Planning and Regulatory. G.Mansfield
Reference: 4785150
Phone: 02 4974 2767

22 January 2016

**NOTIFICATION OF MODIFICATION TO CONCEPT PLAN APPROVAL FOR DAN
LAND 290 & 302 MINMI ROAD FLETCHER (MP06_0031 MOD2)**

Figure 4: Proposed modification (Source: Proponent)

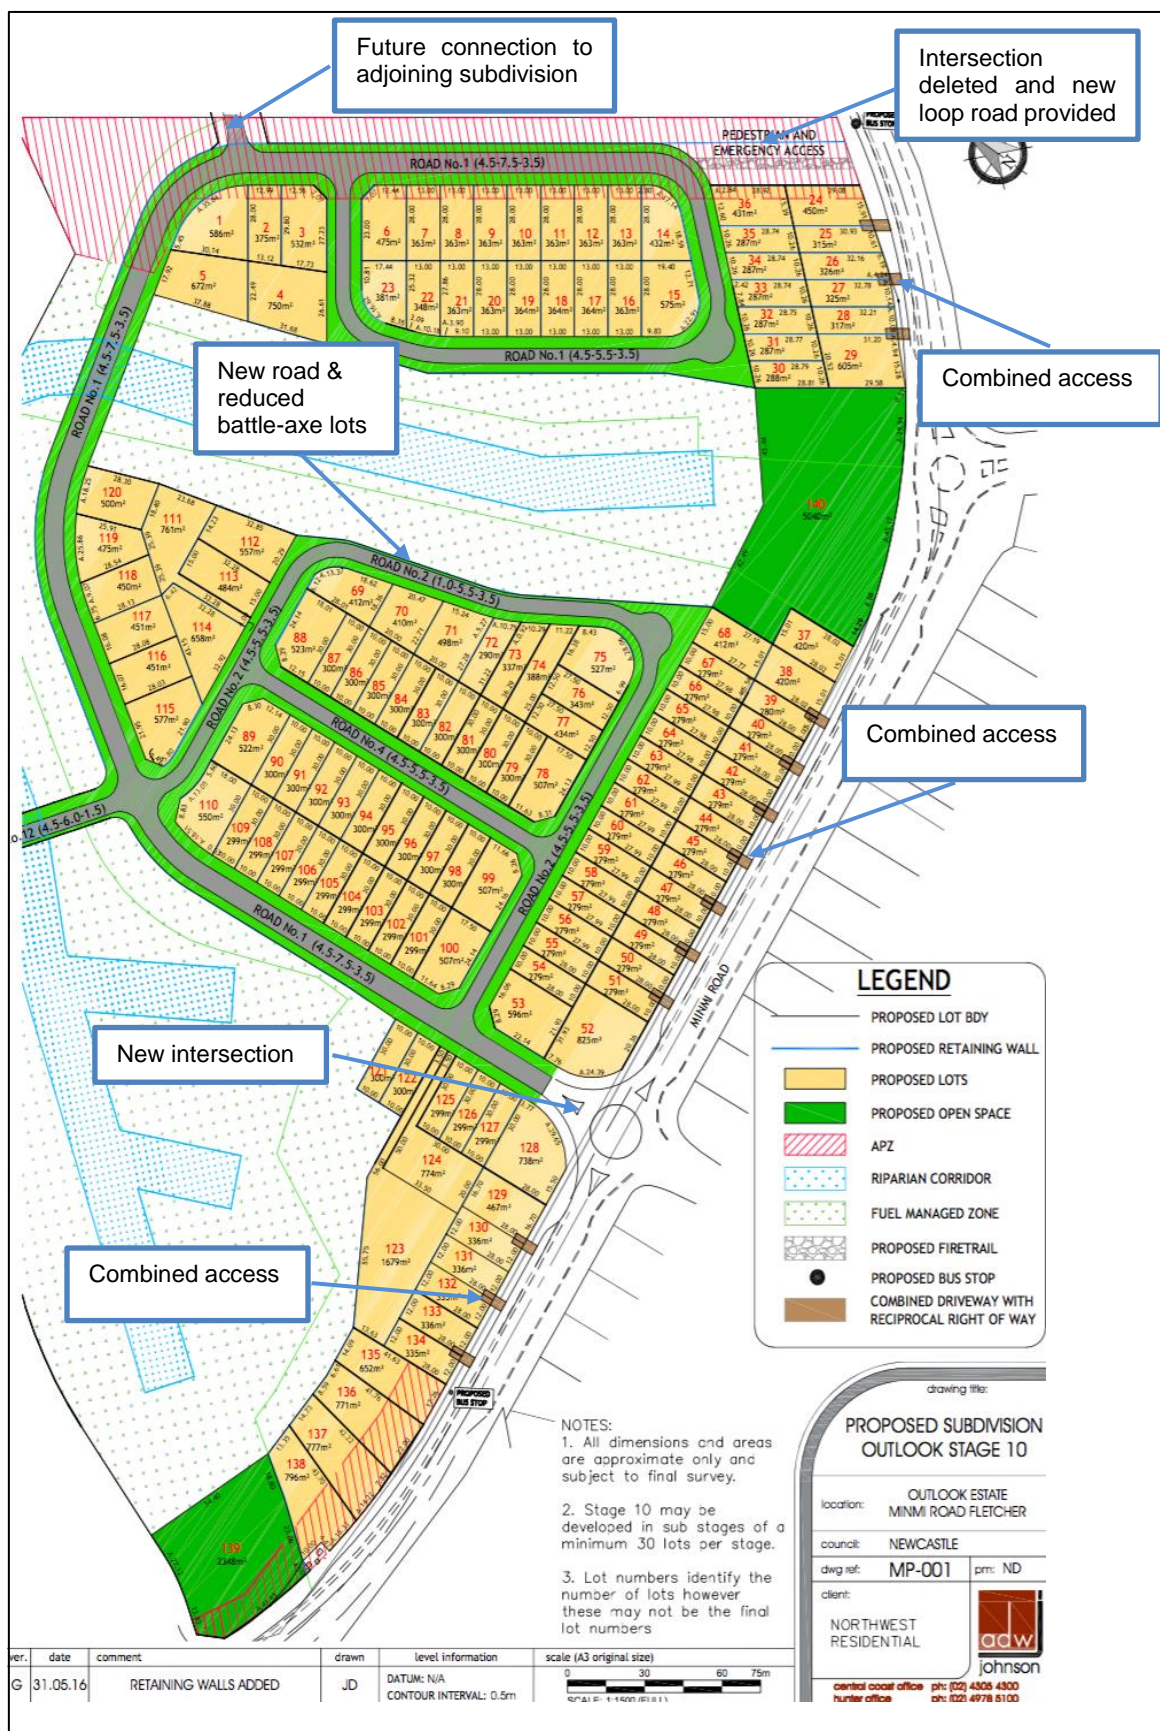
Council's previous submission raised many issues with the original proposal which highlights the need to consider closely the subdivision design for small lot housing. Some of these issues do not appear to have been adequately addressed under the amended plan by ADW Johnson, Ref MP-001, Ver E, dated 26 October 2015. In particular, multiple allotments would require direct vehicular access to Minmi Road. A possible solution to this (as proposed under the design guidelines for MP 10_0090) is to enable access to the rear of the lots via an internal street. A similar approach would appear reasonable by including a rear access laneway between the lots. This would improve vehicular access safety, minimise traffic disruption, improve streetscape appearance and enable improved landscape outcomes along Minmi Road.

While not directly related to the small lots it would also appear that there are still a number of problematic 'battle-axe' style allotments. The current design requires excessively long access driveways in some cases, creating isolated lots with potentially poor amenity. It also results in a number of side boundaries adjoining the open space areas, resulting in poor public access to open space and therefore lack of amenity gain that these areas provide the future residents. Many of these issues may be eliminated by better use of perimeter style road design. For example extending Roads 1 & 2/3 along the frontage of the open space area could improve access and amenity for the allotments and enables improved public access to open space, improved neighbourhood amenity gain, along with improved surveillance

The CPS response to this issue is unsatisfactory. The amended concept plan does not include, as required by conditions B10 (b) and (c), details of the road and pedestrian connection between the residential estates.

In regard to Council's concern regarding the provision of direct access to Minmi Road for Lots 19 to 34 and 1 to 11, the response provided by CPS does not adequately address this issue stating only the proposal is consistent with existing development and recommending extension of the speed limit zone.

The existing development (Highland County) has created road safety issues that Council does not want to replicate in future development; therefore Council has been consistently denying direct access to Minmi Road for developments since the Highland County development has been approved. Therefore, the amended layout is not consistent with recent development approvals in the area and is not supported.
